CITY OF ALBUQUERQUE

RE: **13424 Cedarbrook Ave NE**
Grading and Drainage Plan
Engineer's Stamp Date: 11/27/18
Drainage File: F23D013

RE: **13424 Cedarbrook Ave NE**
Grading and Drainage Plan
Engineer's Stamp Date: 11/5/18
Drainage File: F23D013

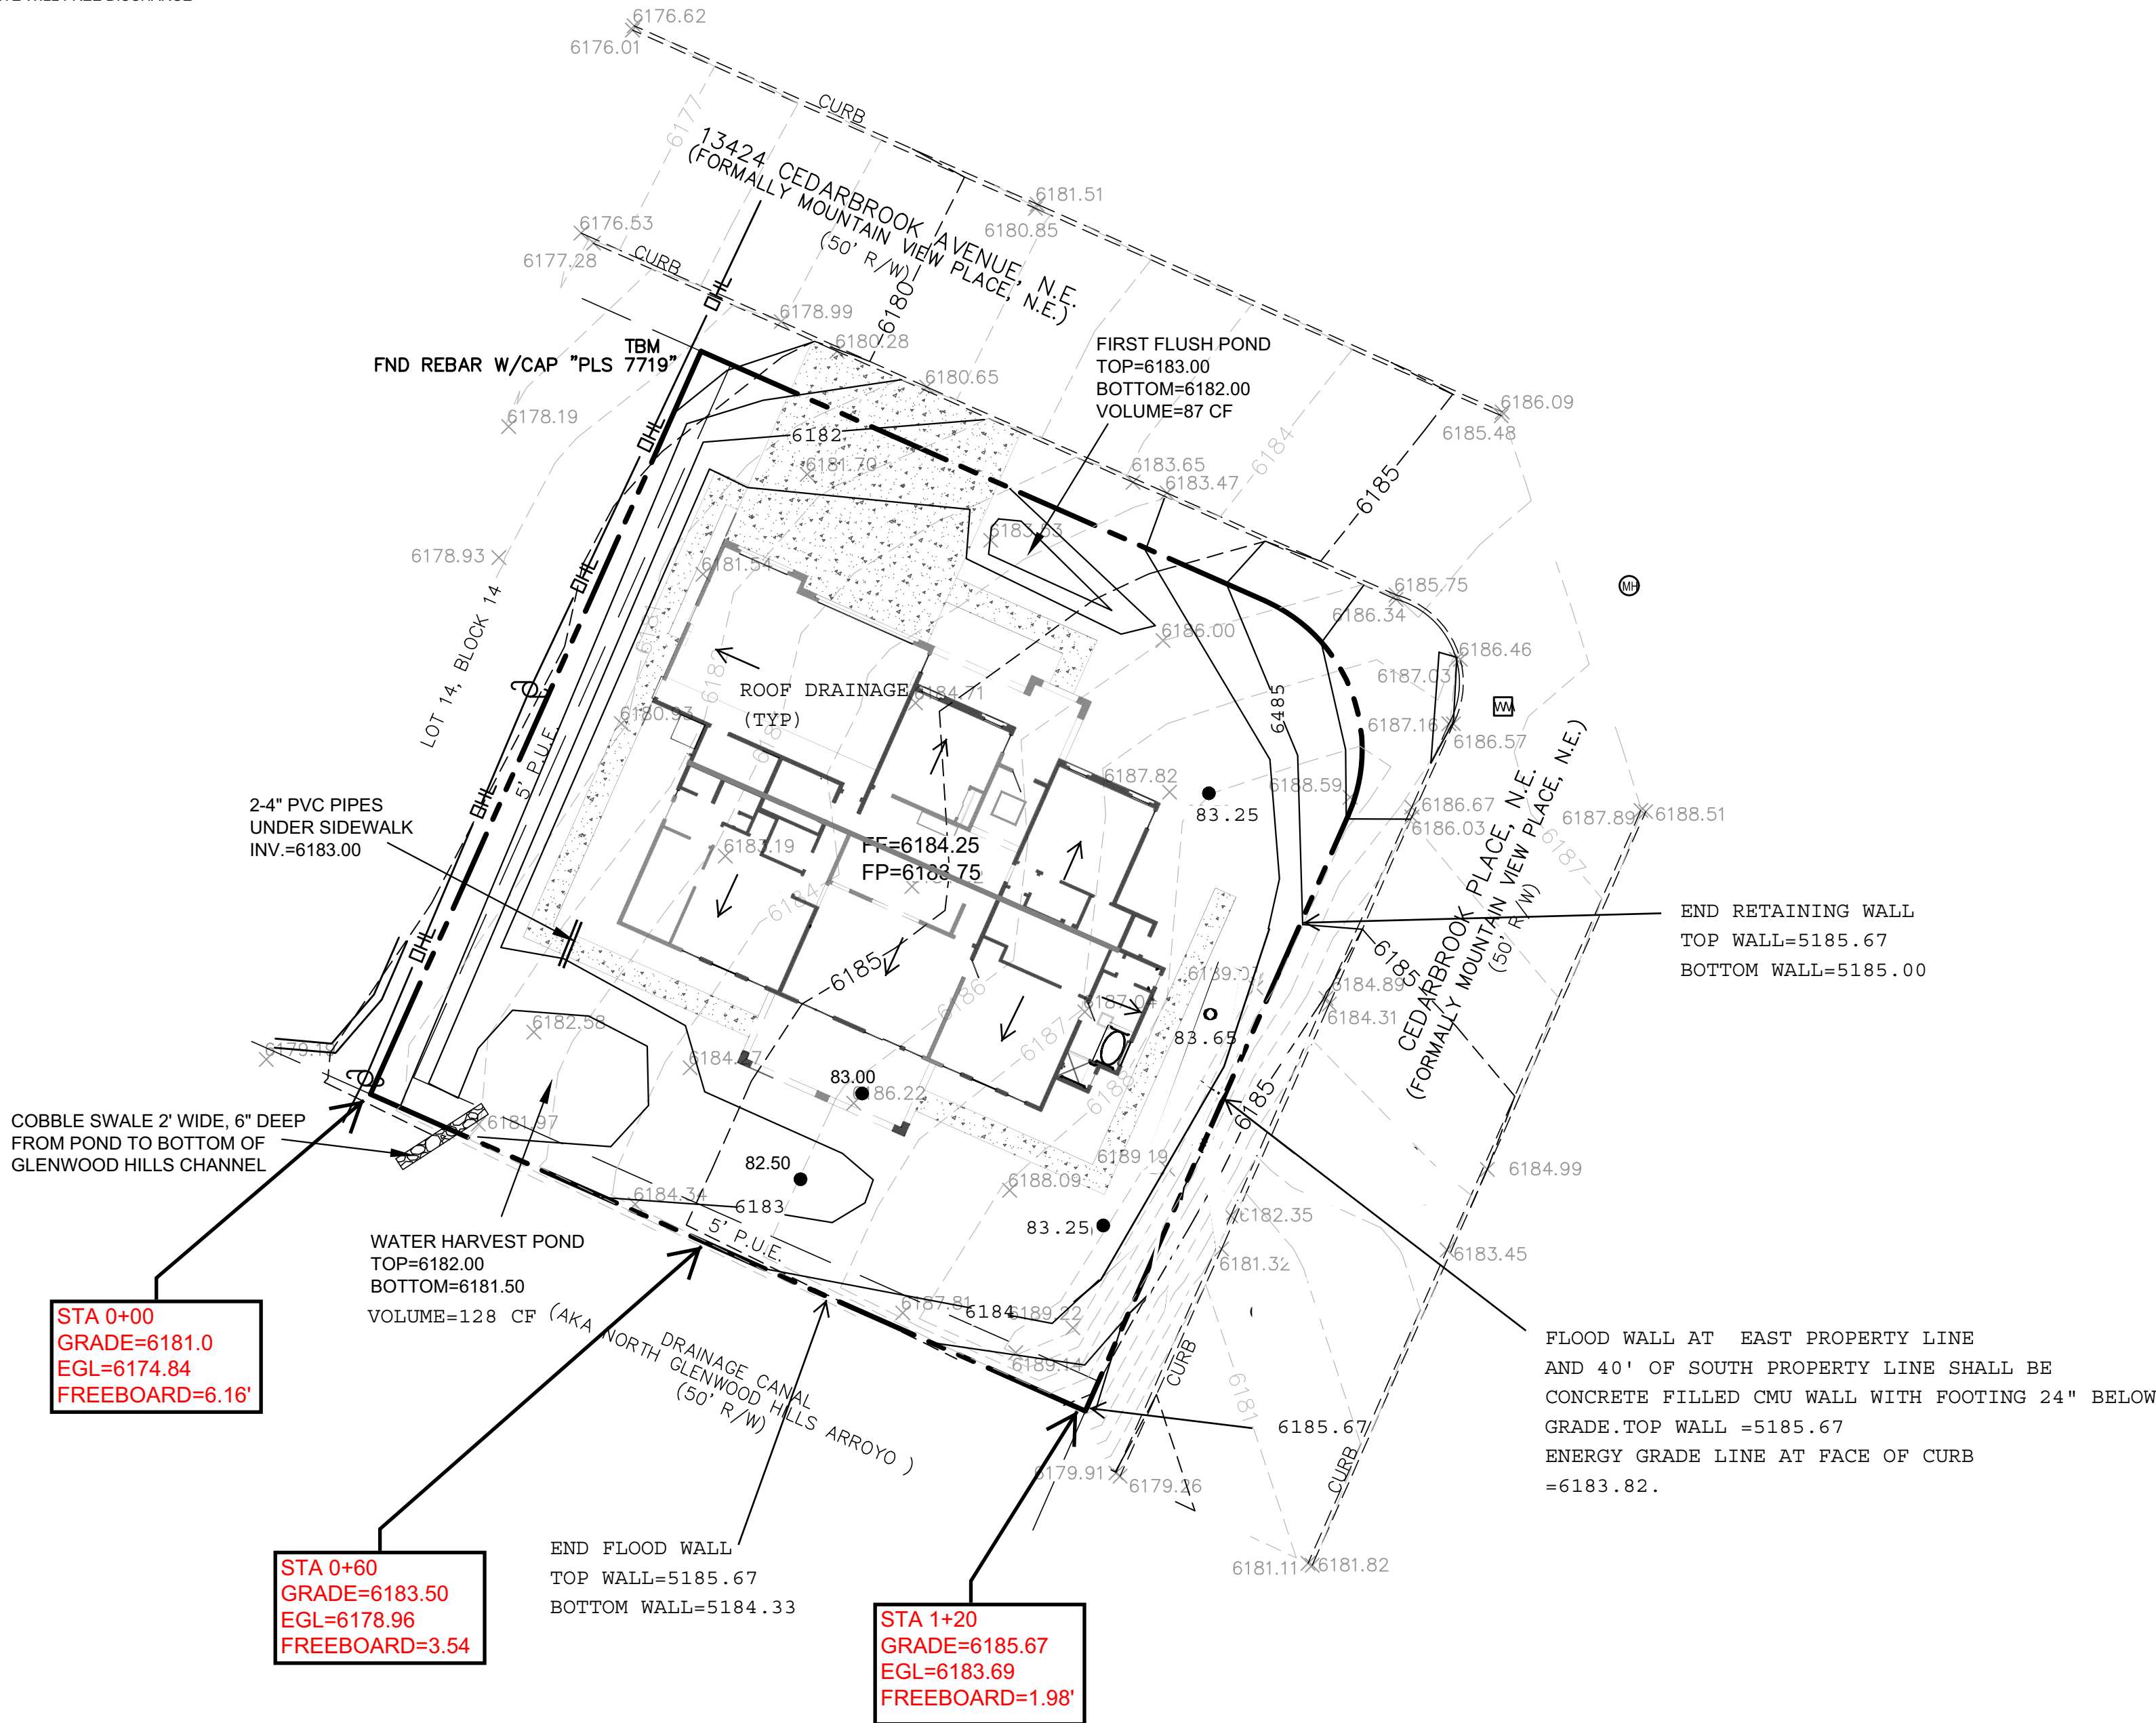
1. Show the freeboard wall in plan view and provide sections (east wall and south wall). Ensure the wall and footer do not encroach on either ROW. Any private encroachment into the public ROW will require a revocable permit.
